City of Albuquerque Stormwater Construction Site Inspection Report

ESC File No. K09E026D & K09E047 (WO)	Project Name:	Westpointe Data Center		
NPDES Id. No. NMR1006JH & NMR1006VU	Location:	8401 Daytona Rd. NW		
5/5/2025	Owner	Contractor		
Operator	CLOP Albuquerque NM LLC	PARIC Corporation		
Contact name & title	David Scott	Kevin Ruck		
e-mail	dave@oppidan.com	KMRuck@paric.com		
Contact Phone #	952-294-0353	636-698-8299		
COA Inspector	James Hughes	Start/End Time:	10:30 AM	
Construction Phase:	Slab and one tilt wall			
Type of Inspection:	Regular	Storm Event	Post Storm Event >0.25"	311/Complaint Follow Up
Weather at time of inspection?	cloudy	Temperature:	~	50
Estimated date of last storm 0.25" or greater	5/4/2025

WESTPOINTE DATA CENTER
SOIL EROSION AND SEDIMENT CONTROL
TEMPORARY ESC PLAN

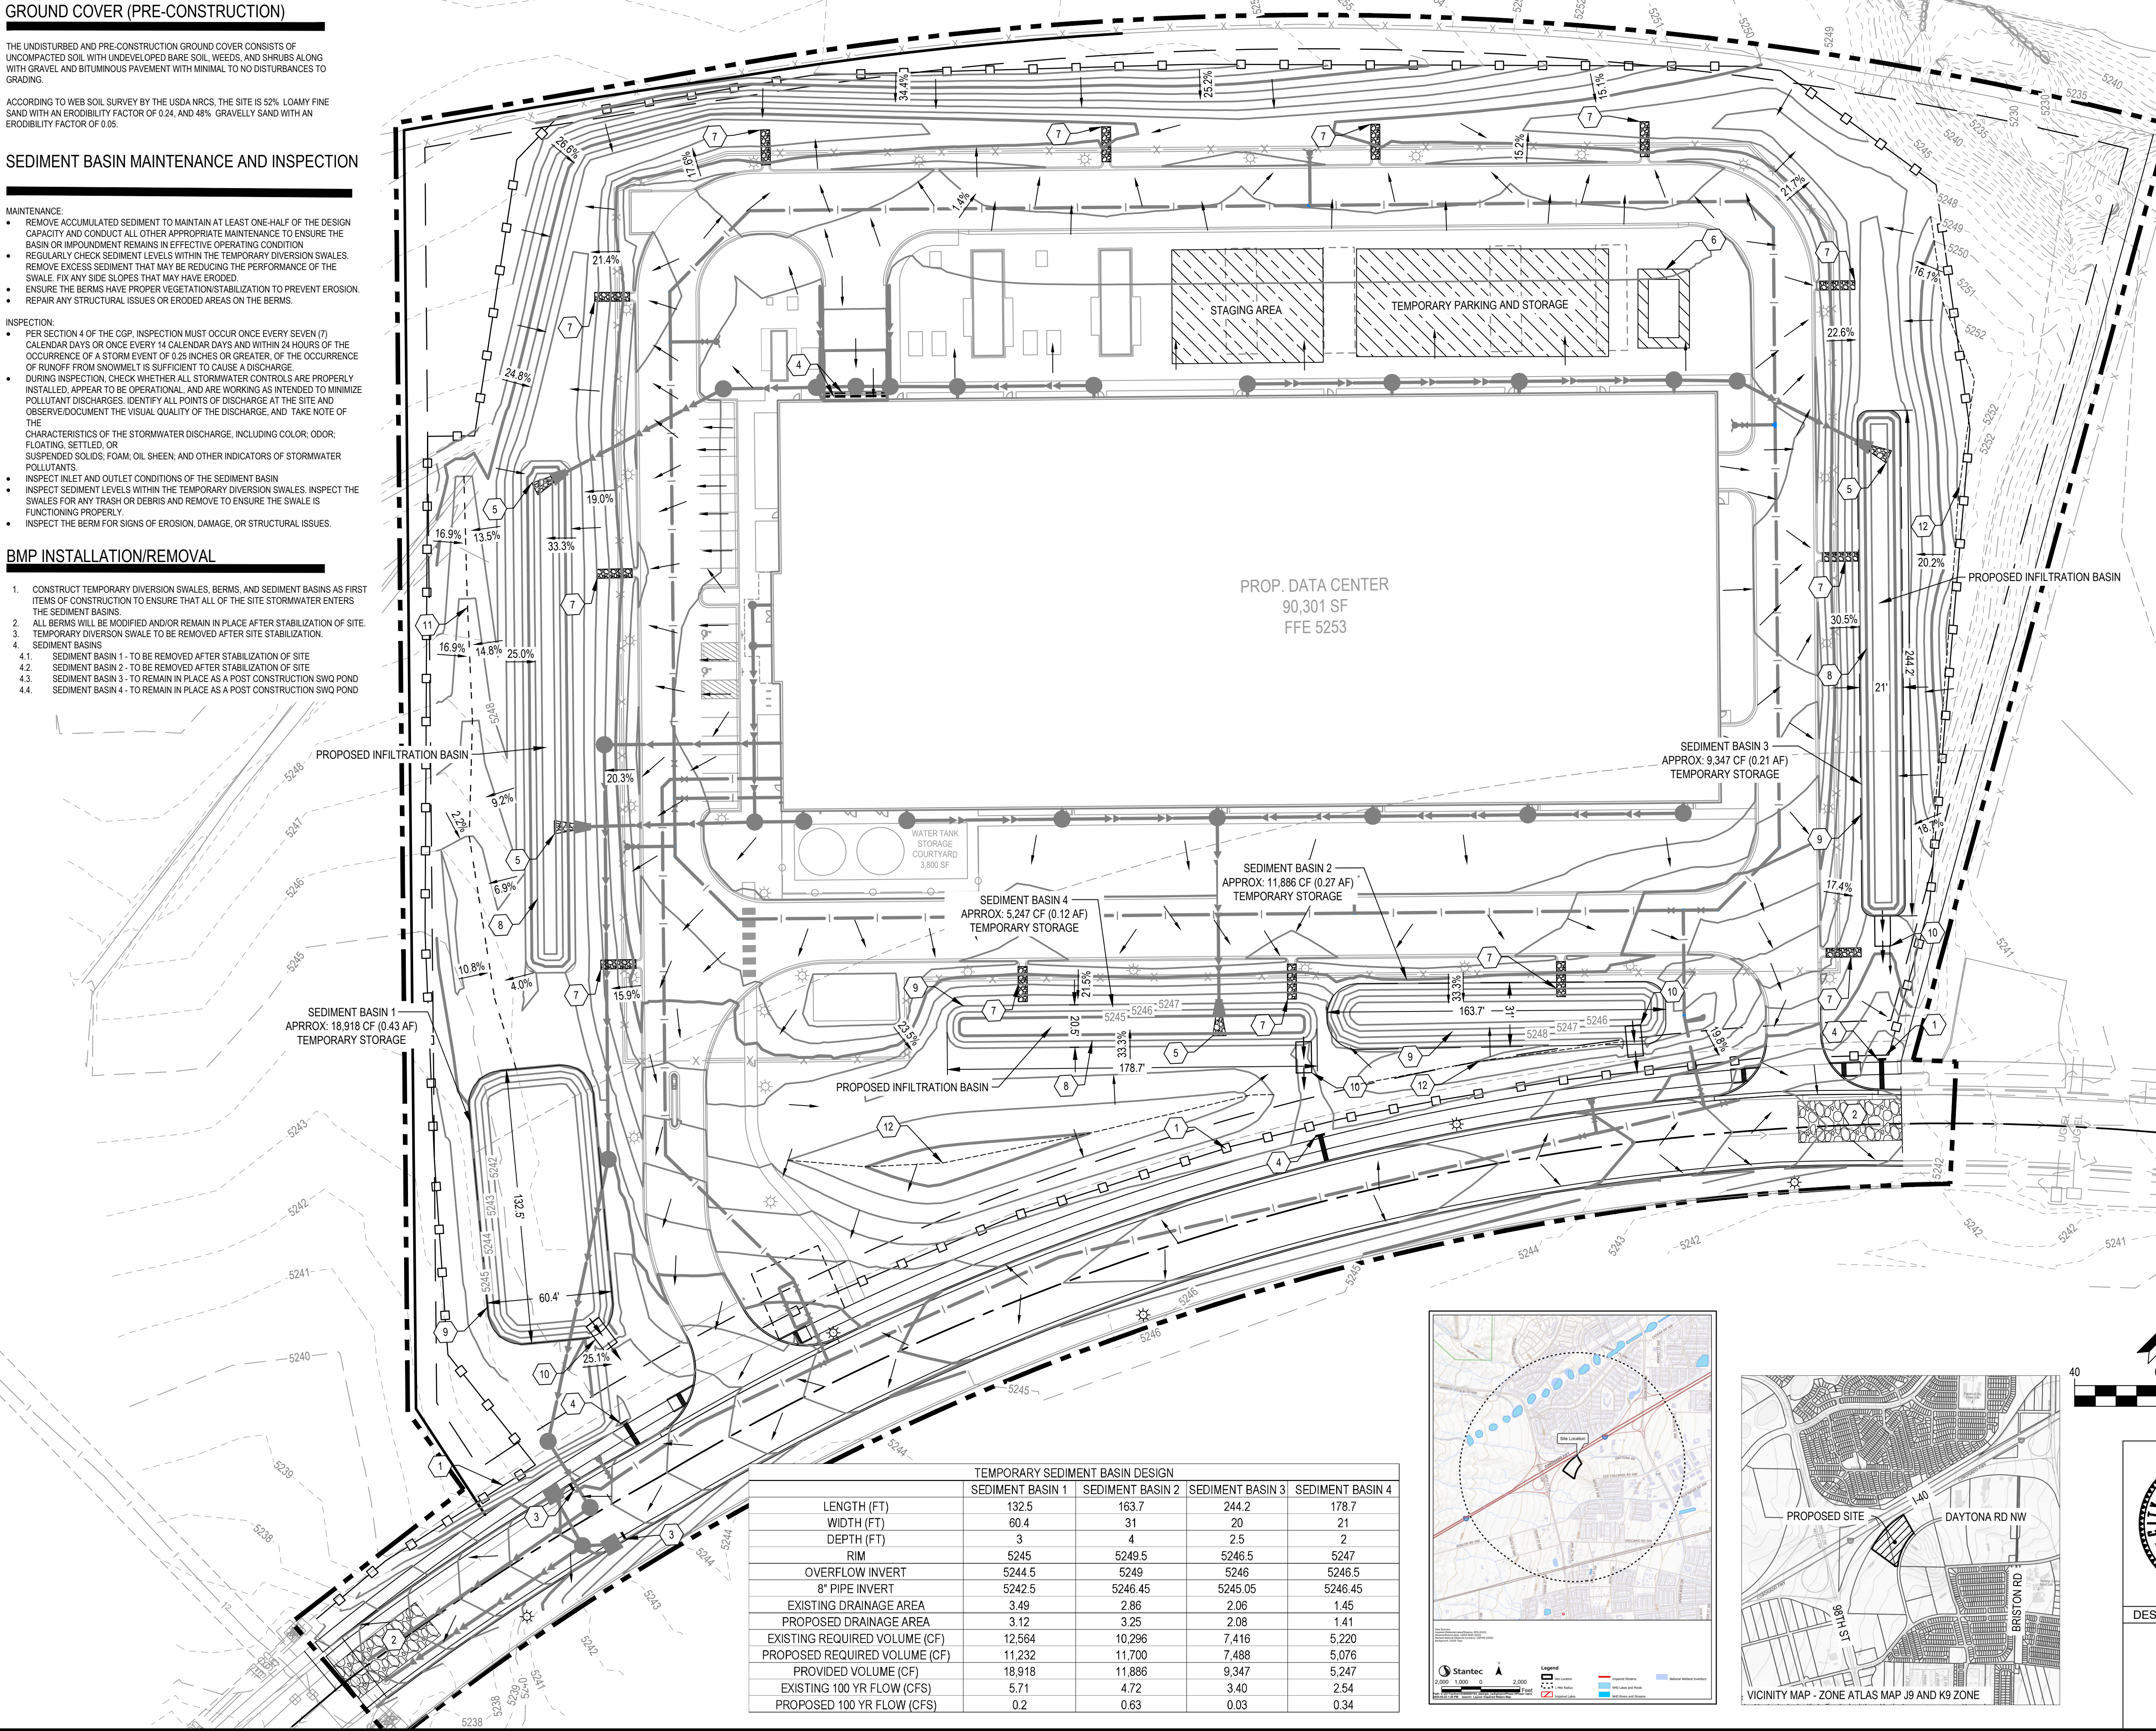
Item Number	Deficiency/ Corrective Action			
1	<p>BMPs - Erosion and sediment controls were not implemented and maintained as shown on the approved ESC Plan dated 10/17/24 in violation of CGP 2.1. Specifically, sediment basins and swales are missing all across the south side of this site. Required mitigation: If at any time you find that a stormwater control needs routine Maintenance, you must immediately initiate the needed maintenance work and complete such work by the close of the next business day. The missing ponds and swales are part of a "Corrective Action" so they must be installed and made operational by no later than seven (7) calendar days from the time of discovery per CGP 5.2.1. You must also complete a Corrective Action Report</p>			
2	<p>The SWPPP and self-inspection reports were missing the owner/operator's signature on the certification statements. Two people from PARIC Corporation signed each report, and no one from CLOP Albuquerque, NM LLC., in violation of CGP G.11.2. The approved SWPPP Map dated 10/17/2024 was missing from the SWPPP. Required Mitigation: Since you have not delegated your signature authority to an employee, you personally must sign the certification statements on the SWPPP and all reports. You may not delegate your signature authority to an employee of a third party outside of the CLOP Albuquerque NM LLC. The SWPPP, including the SWPPP Map, Self-Inspection Reports, and Corrective Action Reports, must be kept up-to-date per CGP 7.1 and available on-site per CGP 4.7.3, 5.4.3 and 7.3. If an on-site location is unavailable to keep the SWPPP when no personnel are present, notice of the plan's location must be posted near the main entrance of your construction site CGP 7.3.</p>
